Waddington Parish Council

25th January 2021

Application reference: 3/2021/0033
School House, West Bradford Road, Waddington

Side Elevation
Scale 1:100

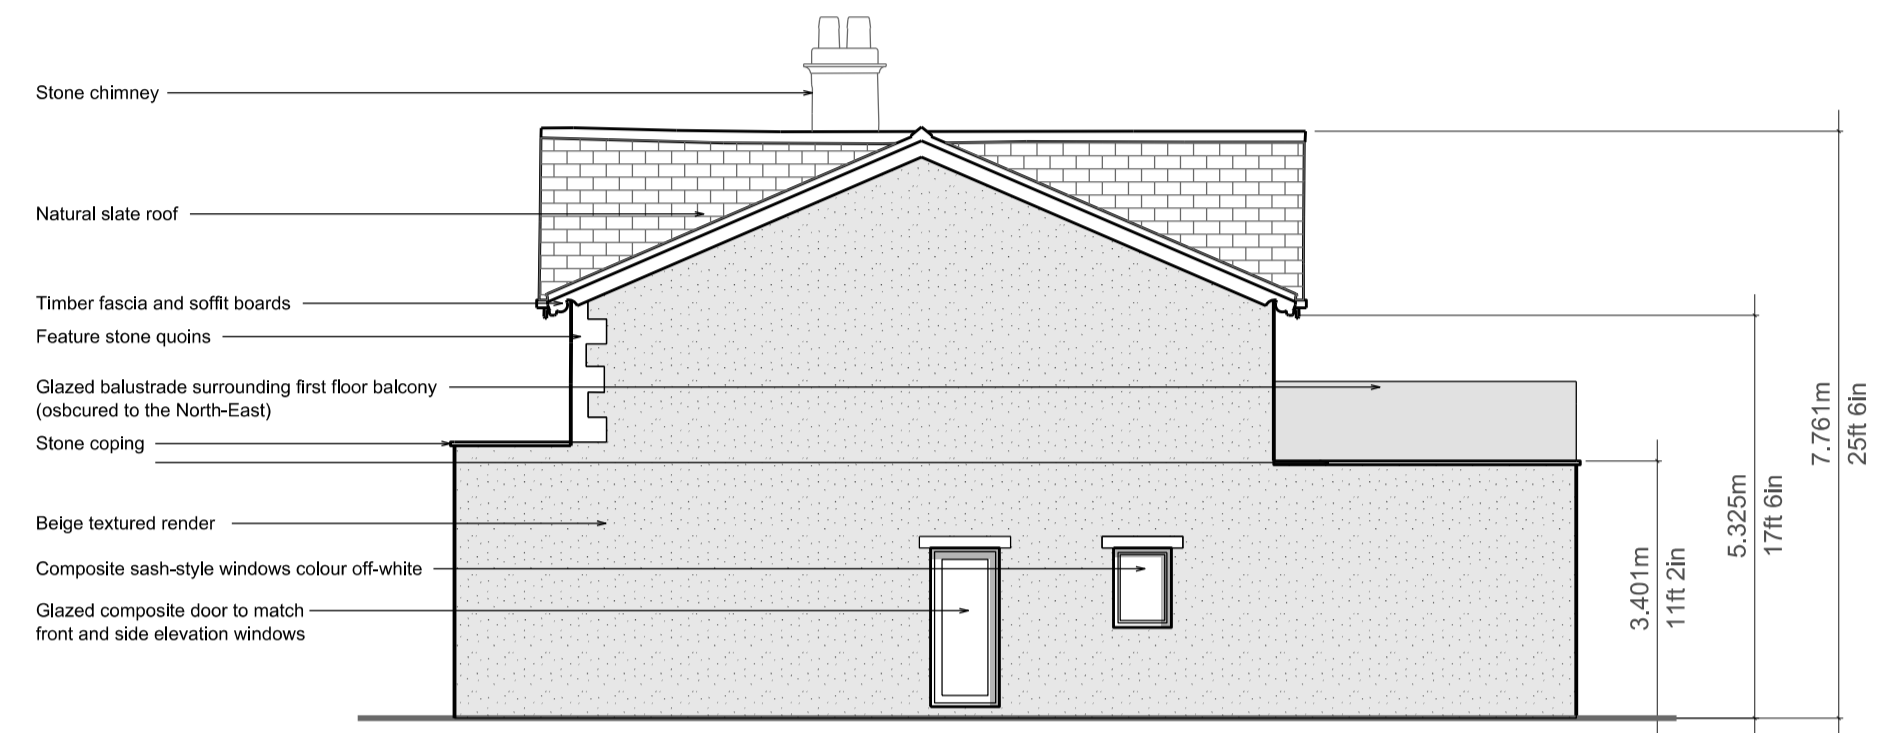
If Ribble Valley Borough Council intends to grant permission for the above planning application, we urge you to make installation of three swift nest bricks a planning condition, thereby providing a communal habitat of three nest bricks to the new gable end of the building.

All is not lost, however. There are lots of simple and inexpensive solutions, easily deployed in all manner of developments which addresses the issue - swift bricks being one such example. The only pre-requisite is that the bricks should be sited above 5m from the ground, which is possible at this site with the gable ridge being at 7.8m.

We enclose an annex which lists a range of possible solutions, products and resources, including boxes to suit an external random stone finish as proposed.

We therefore urge the RVBC to include the above condition for the developer to provide swift nest sites integral to the new extension as a biodiversity enhancement to this development.
